From: [Shay Kelleher](#)
To: [SIDS](#)
Cc: [Lauren Griffin](#)
Subject: PAX91.323635_Garrane Windfarm
Date: Tuesday 7 October 2025 12:57:05
Attachments: [Outlook-taqwmlz.png](#)
[Outlook-bsza4t1z.png](#)
[Outlook-pyafnhxz.png](#)
[Outlook-piihf2b2.png](#)
[Outlook-Text Desc](#)
[PAX91_323635_Garrane windfarm_limerick_Heritage Council Submission.pdf](#)

Re: 9 no. wind turbines, grid connection, and all associated site works. Located in the townlands of Garrane, Ballynagoul, Creggane and Charleville, Co. Limerick.

Planning Ref: PAX91.323635

Re: 9 no. wind turbines, grid connection, and all associated site works. Located in the townlands of Garrane, Ballynagoul, Creggane and Charleville, Co. Limerick.

Proposed Planting Scheme

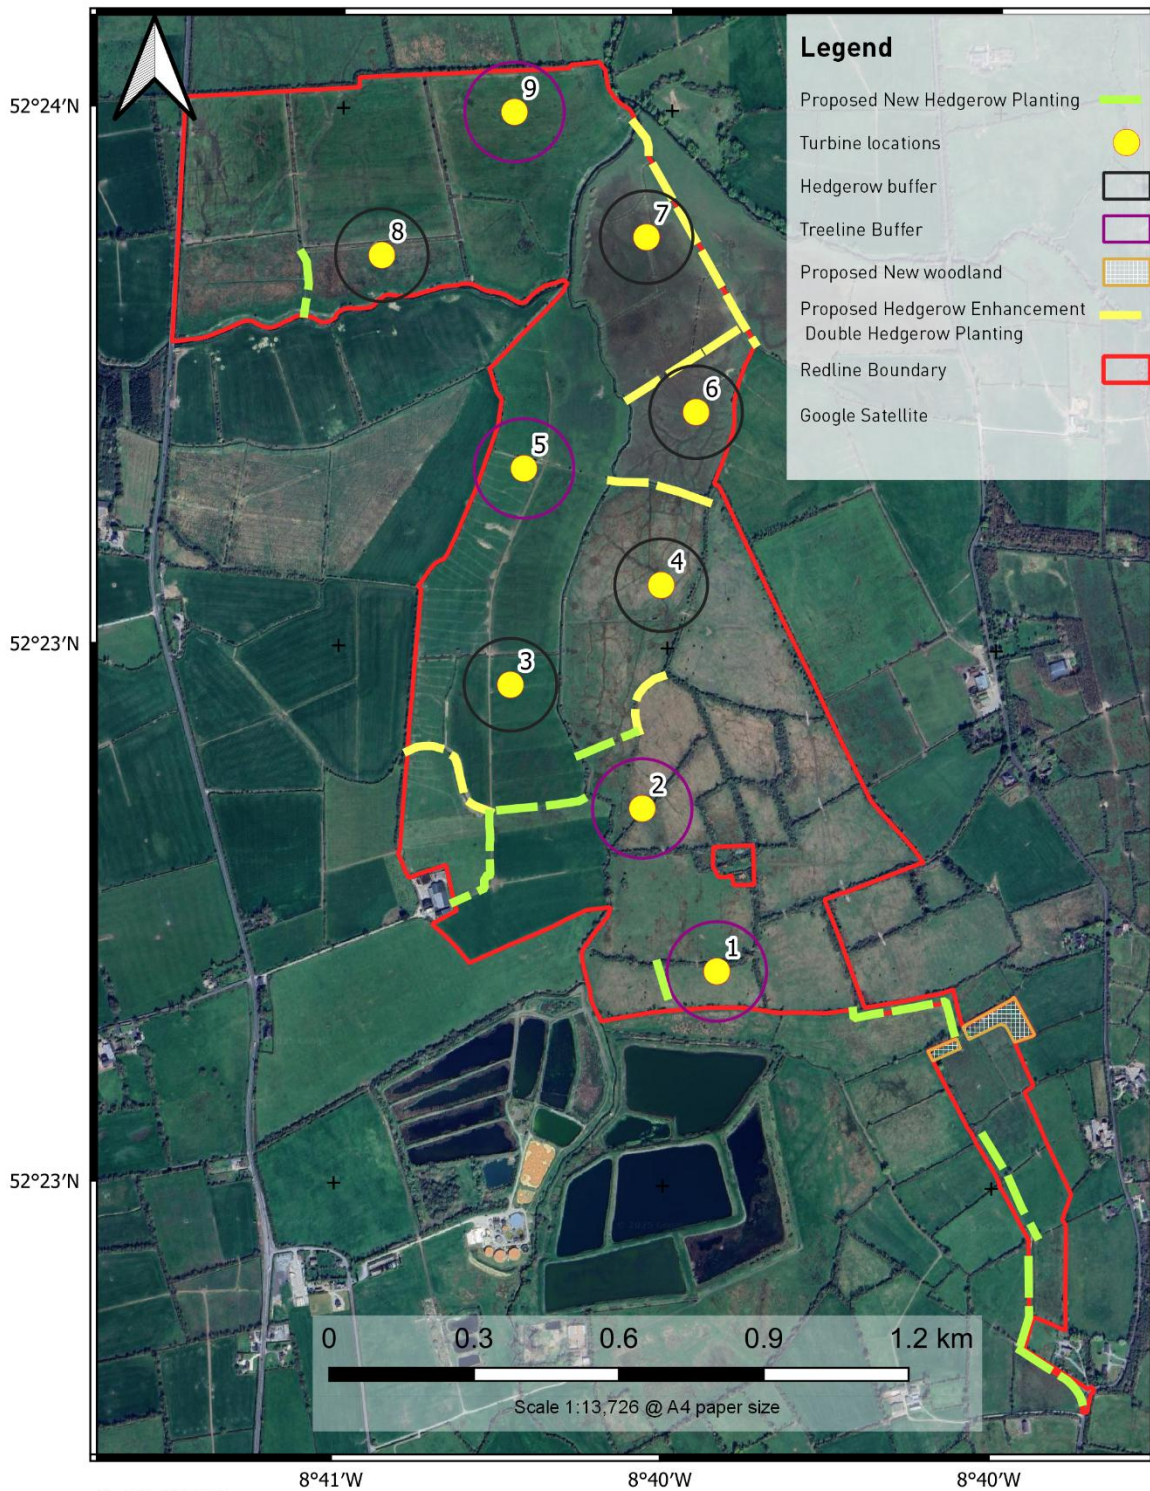
In terms of other habitats, there is a significant loss of hedgerow habitat (the densest network also appears be around wet grassland habitats), although it is acknowledged that a substantial proportion of this is for bat mitigation. The mitigation as proposed should be secured by condition, with strict implementation of the biodiversity enhancement plan being a fundamental pre-requisite. In addition, the curtailment and monitoring regimes regarding bat mitigation should also be secured by condition.
